Your ref
Our ref TL /3/2013/0357
Date 5th June 2013

Planning application no: 3/2013/0357

Proposal: Erection of a 60.7m single wind turbine.

Location: Land to the north of Huntroyd Home Farm, Huntroyd West, Whins Lane, Simonstone, Lancashire BB12 7QL.

NOTES		EMPIRICA INVESTMENTS Ltd	INDICATIVE ACCESS ROUTE	 carl TONKS consulting 523 Horizon, Broad Wier, Bristol BS1 3DJ T - 0117 382 0507 M - 07866 543939 www.tonks-consulting.co.uk	A		
					FIG 6.1	N.T.S@A3	
					2012-F-001-2013-018		
HUNTROYDE

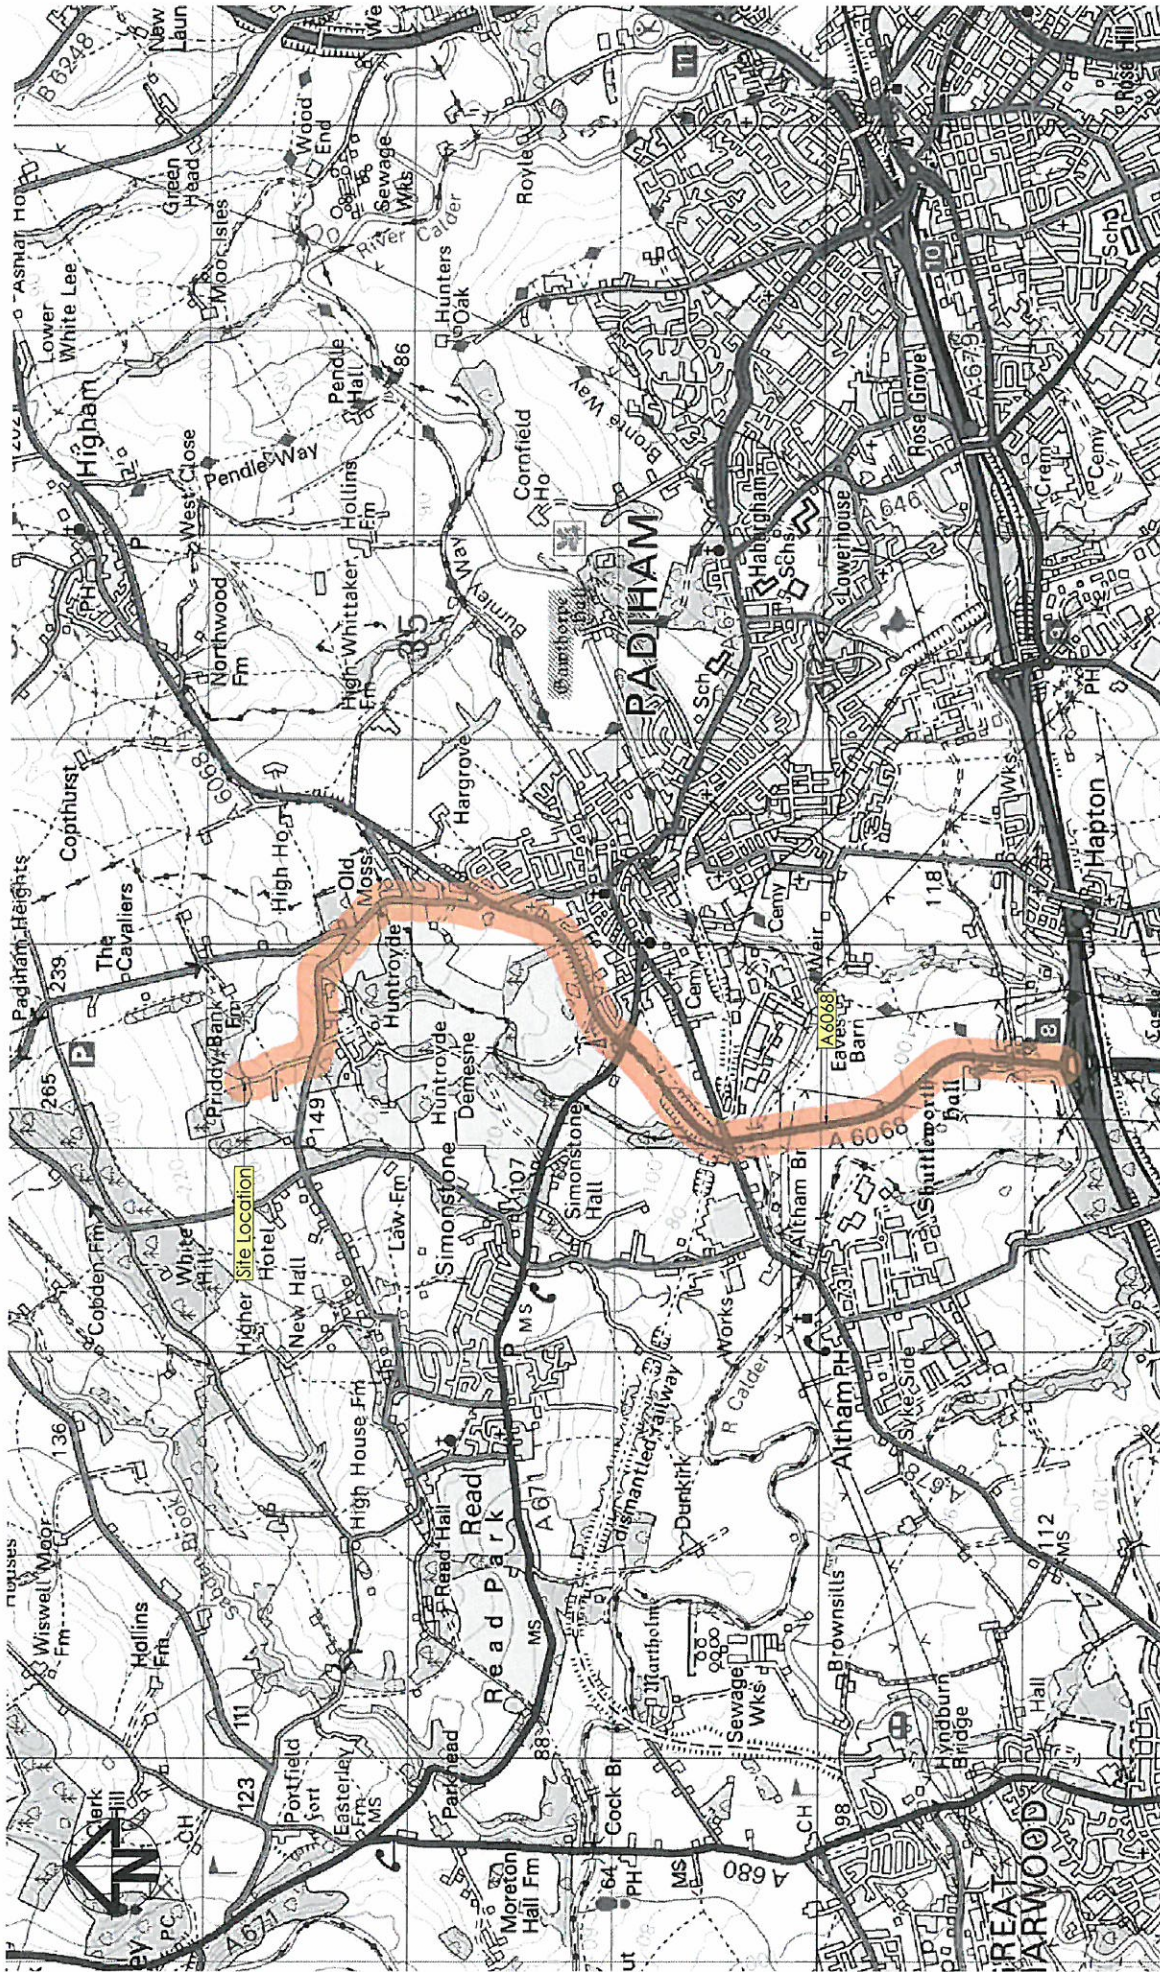
I consider that there is likely to be a problem with the route in as much as the crossing of bridge # 1116B1 Wallgreen located on Whins Lane. The record show a HB assessment of 19.5 with a caveat of "Needs rebuilding, no imminent danger of collapse". This being the case and with the extra traffic generated in building the turbine foundation I would suggest that the use of this part of the network should not be permitted without further detailed assessment of structure to see if it is suitable to carry the extra traffic associated with the construction of the foundation and erection of a wind turbine.

It maybe possible that another route could be found that avoids the use of Wallgreen Bridge by the use of School Lane/Trapp Lane.
